Re: Proposed Change of Use, 51 Sea Lane, Rustington. Ref: R/184/17/PD

We wish to register our objection to this proposed change of use, from retail (Class A1) to a restaurant/café (Class 3).

**APPENDIX ONE:
DRAWING SHOWING EXTERNAL EXTRACT AND VENTILATION EQUIPMENT PROPOSED**

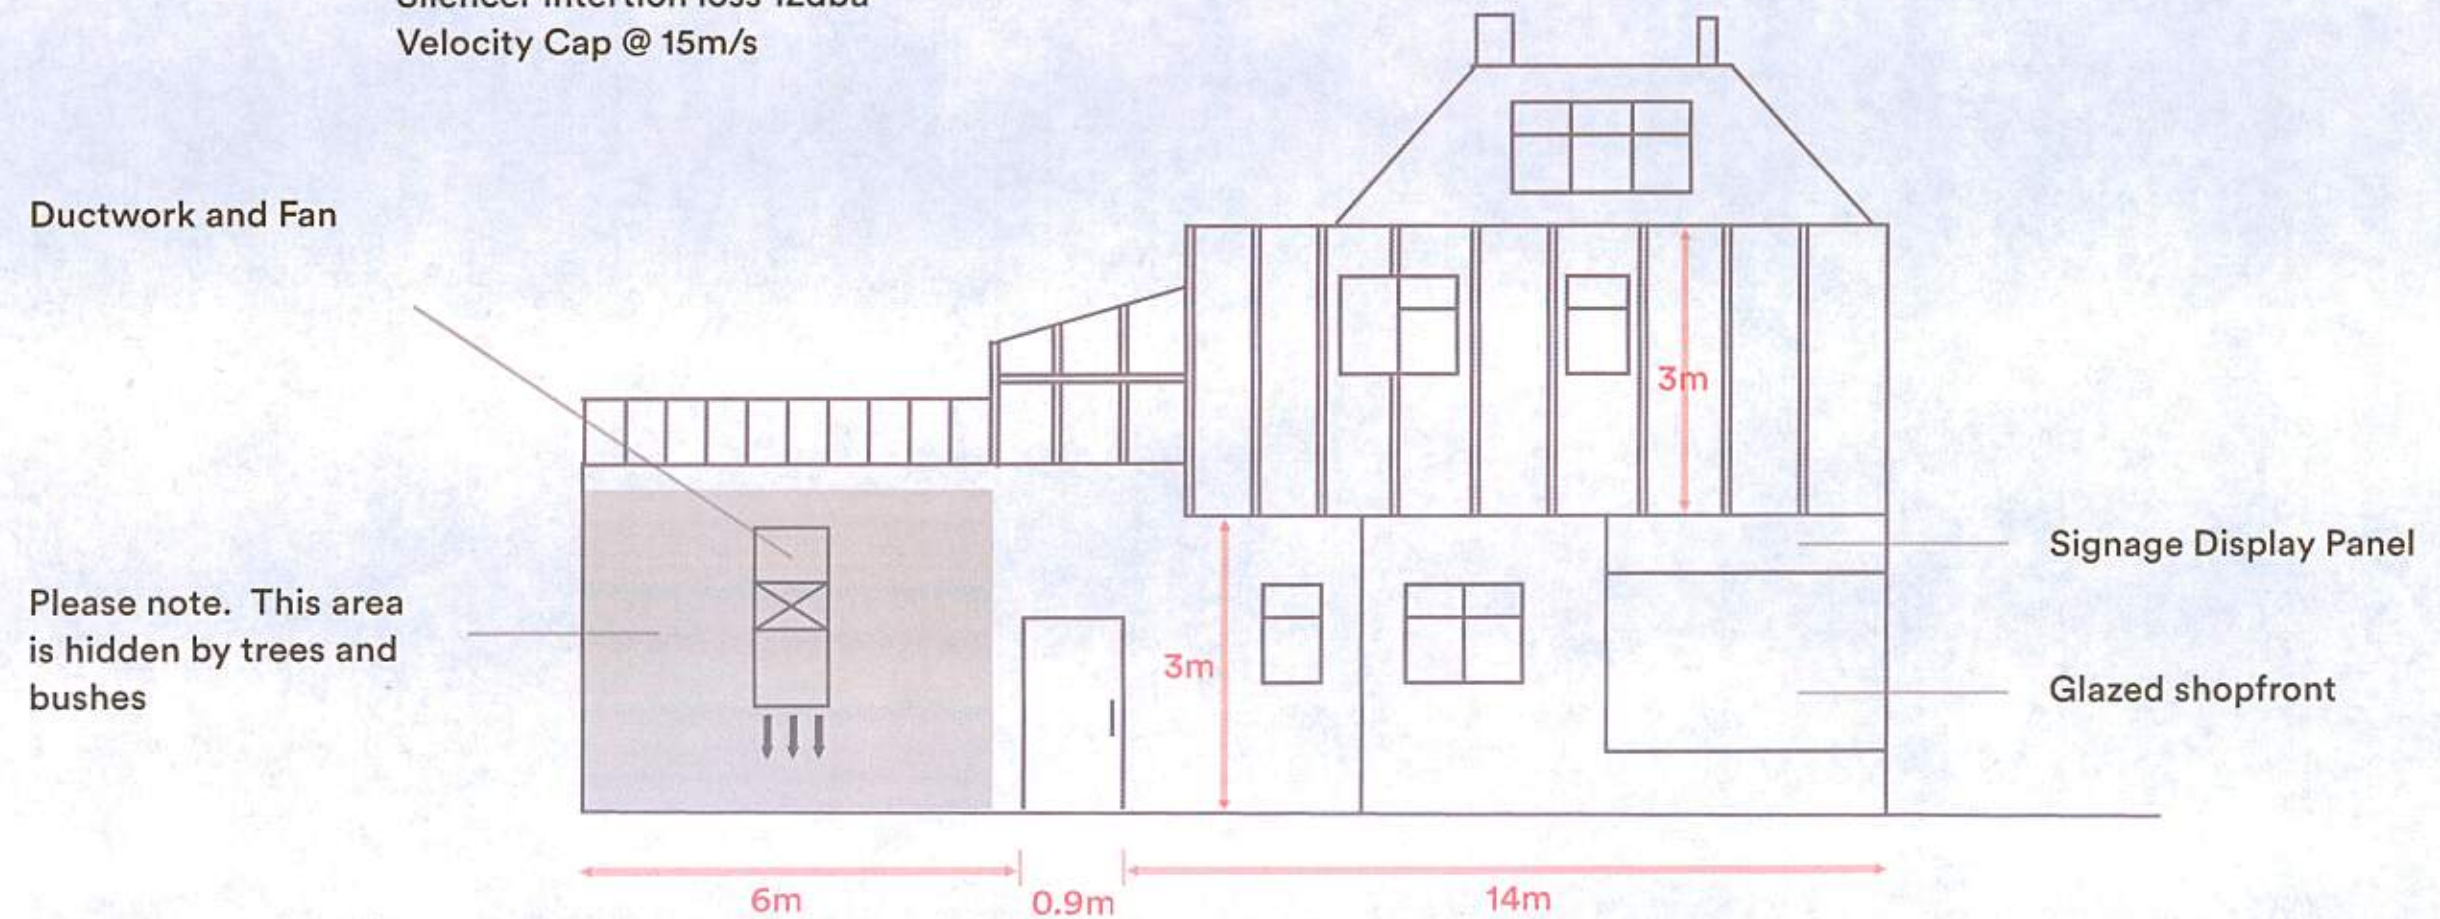
The plans show a ventilation system, whose outlet would be on the north-facing wall towards the rear of the building. Quite apart from the unsightly appearance and noise of this equipment, any smells emanating from the catering would be vented towards the properties immediately adjacent, given that the prevailing wind comes from the South West.

APPENDIX TWO:
DRAWING SHOWING PROPOSED REFUSE FACILITIES

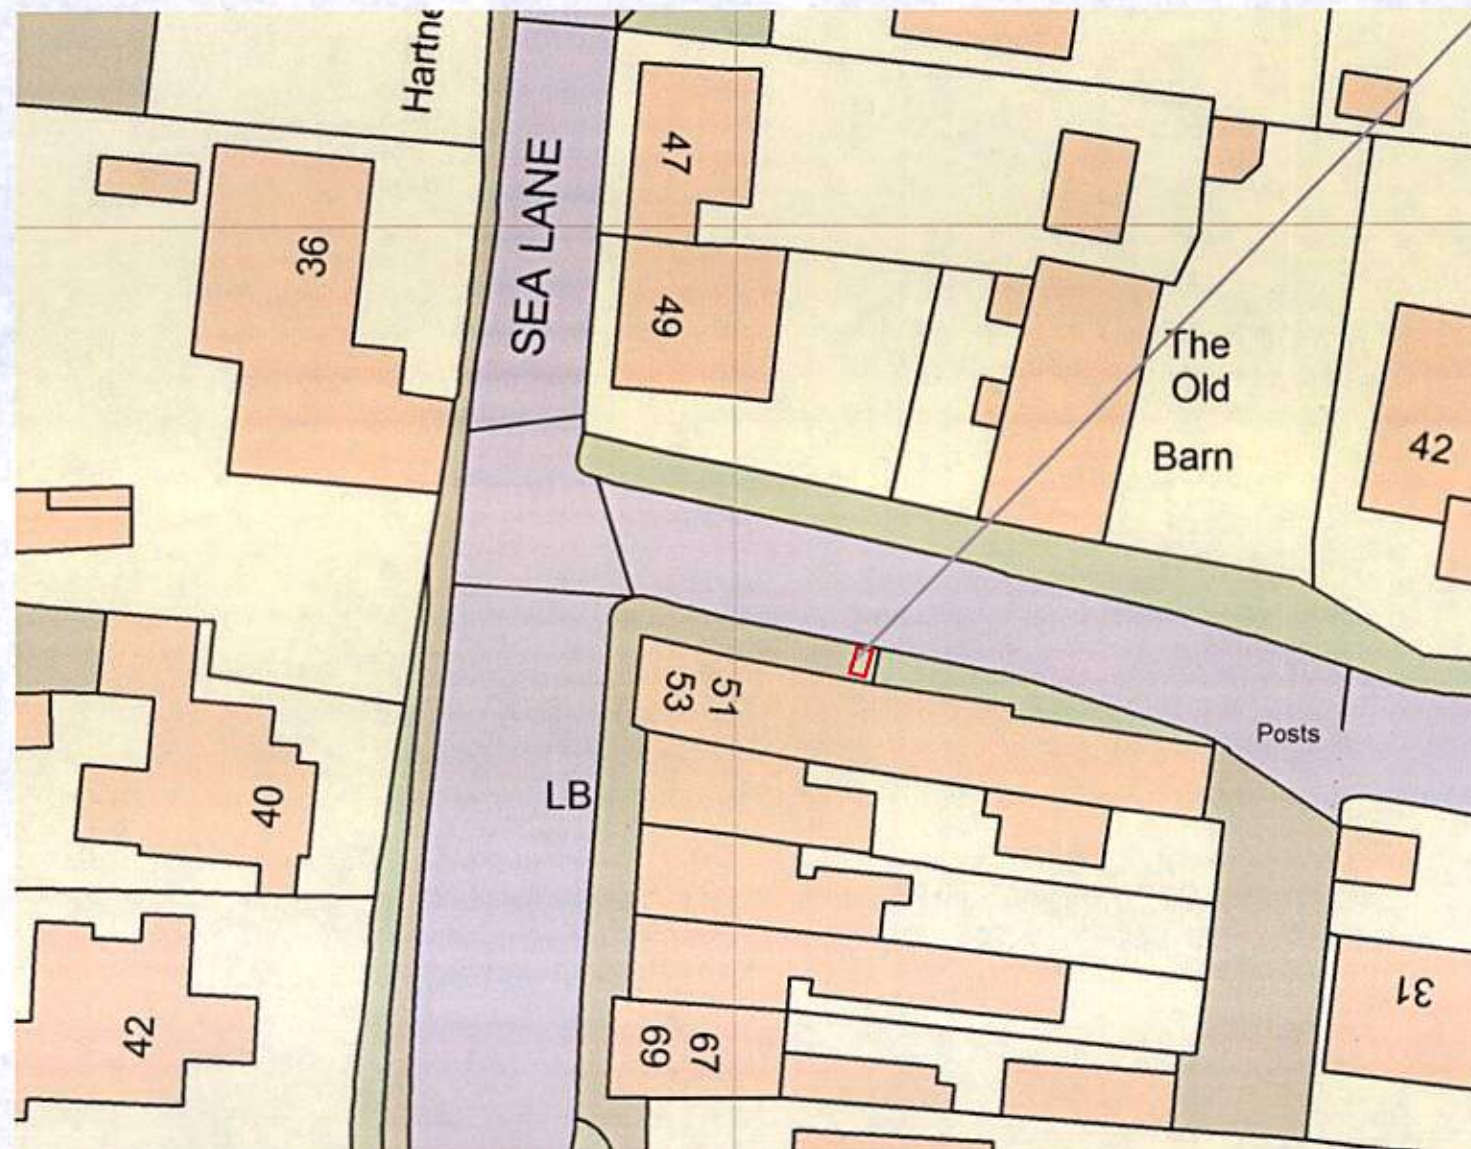
Finally, the issue of food waste and other refuse raises the unpleasant prospect of attracting vermin, more foxes, gulls, rats and mice.
